October 6, 2022

Re: Public Comment - File No. 2207-019
6950 SE Maker Street/Parcel No. 9350900620

MERCER RESIDENCE  
6950 SE MAKER ST MERCER ISLAND, WA

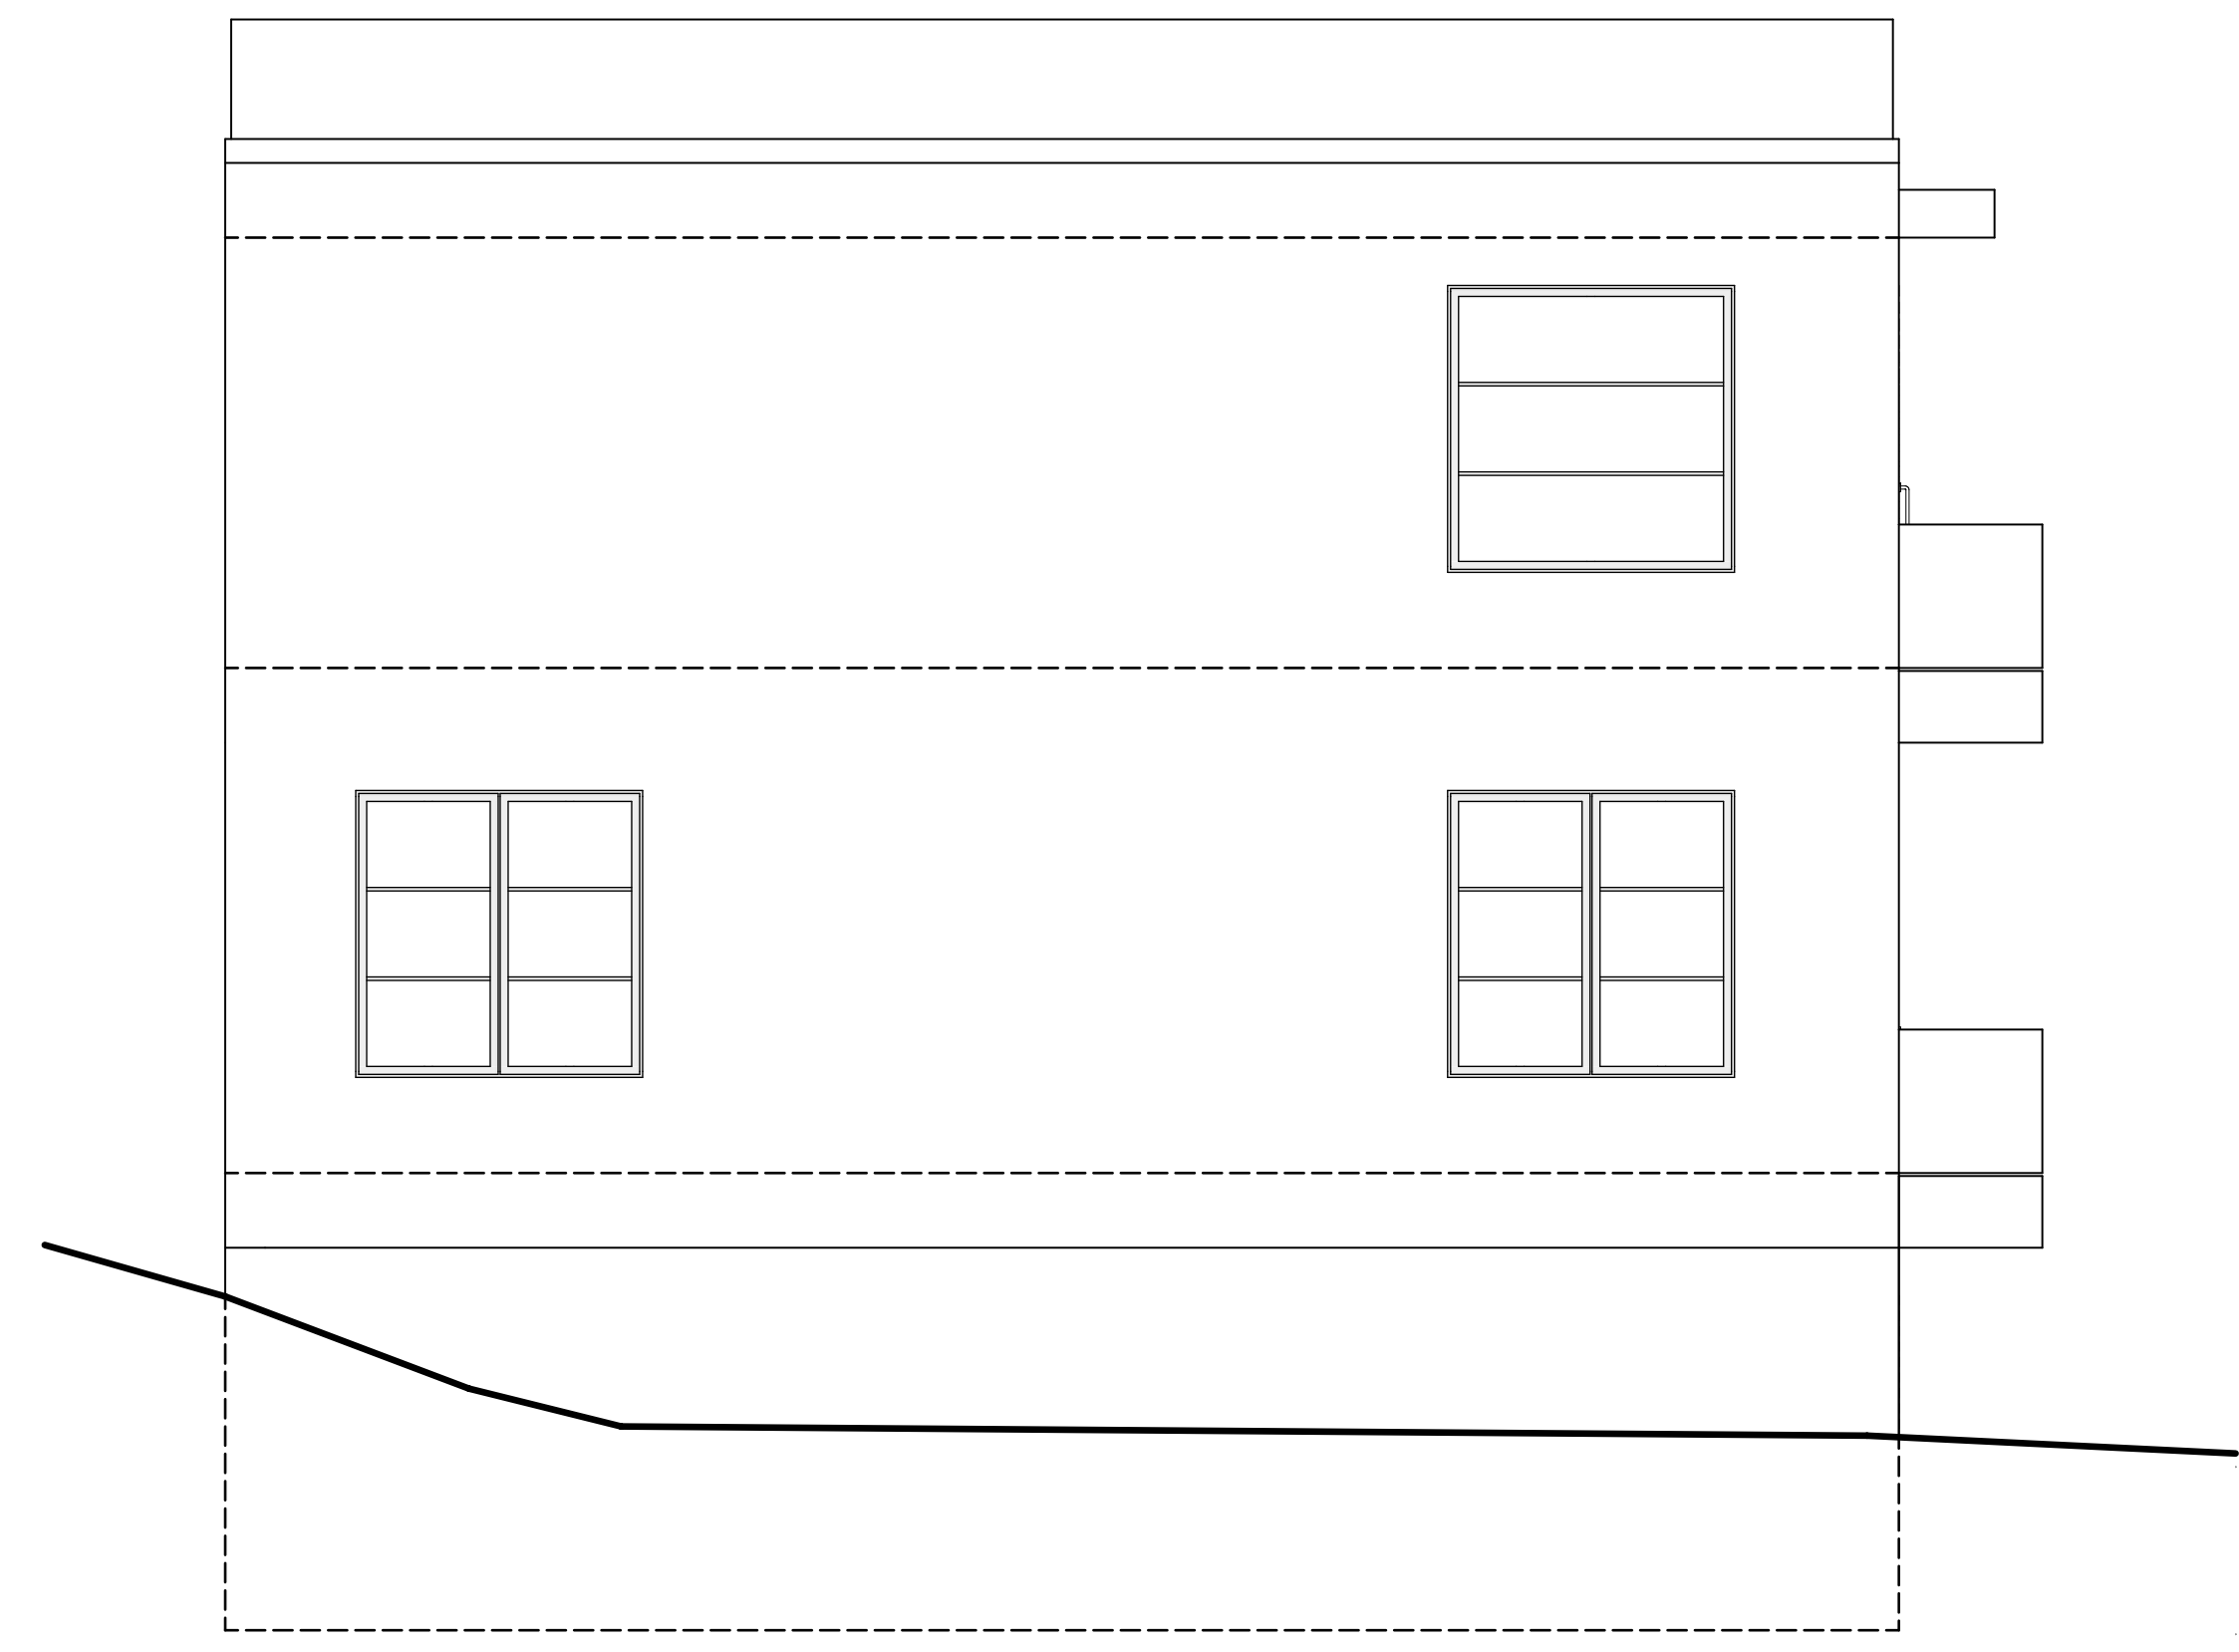
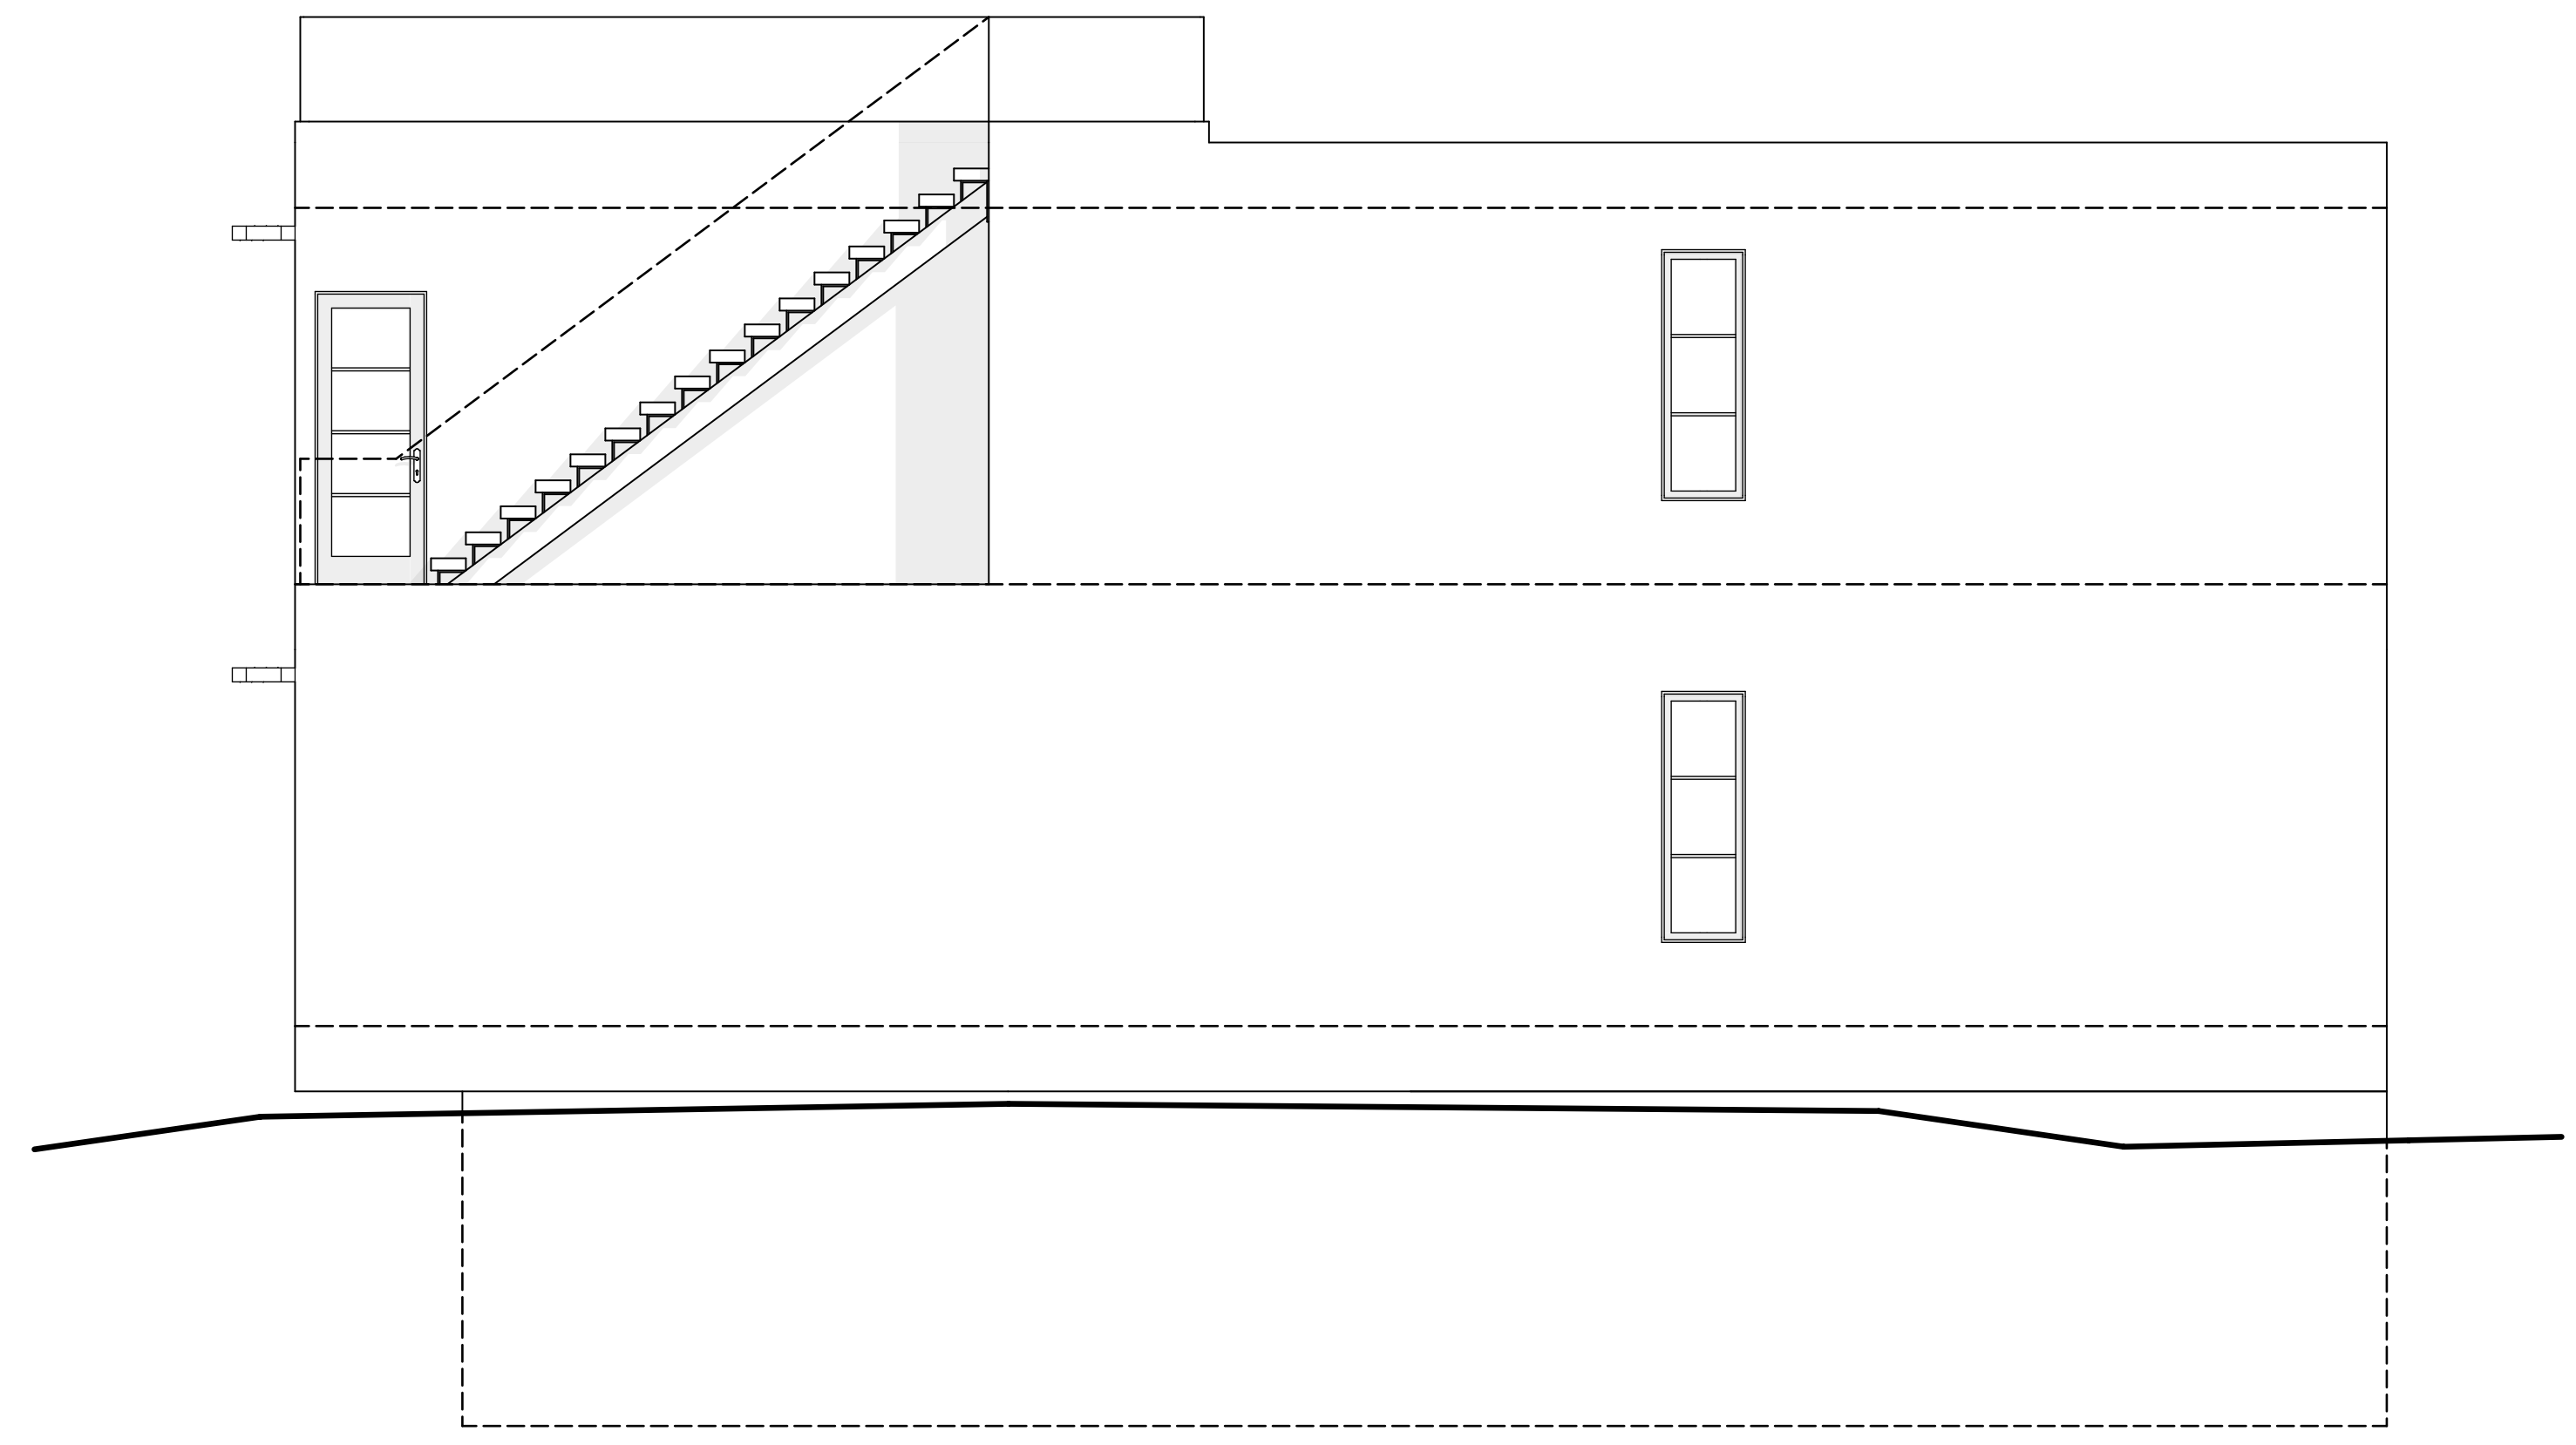
A. In particular, we share the concerns that the Project does not properly calculate the Existing Grade of the Site, as defined in MICC 19.16, in determining the permitted height for the Project. This results in a proposed residence that would be substantially taller than permitted by the MICC and would loom high above the rest of the homes in the neighborhood. We are also concerned that the rockery retaining walls that support a substantial amount of fill

Notwithstanding the substantial amount of fill located on the Site, the Proposal does not appear to use the Site's "Existing Grade," as defined by MICC19.16.010, to determine the permitted height of the proposed residence at the Site. Use of the appropriate Existing Grade, i.e., the grade prior to bringing a substantial amount of fill to the Site, would reduce the permitted height of the proposed residence by several feet, creating a structure less out of scale to the neighborhood and in compliance with the MICC.
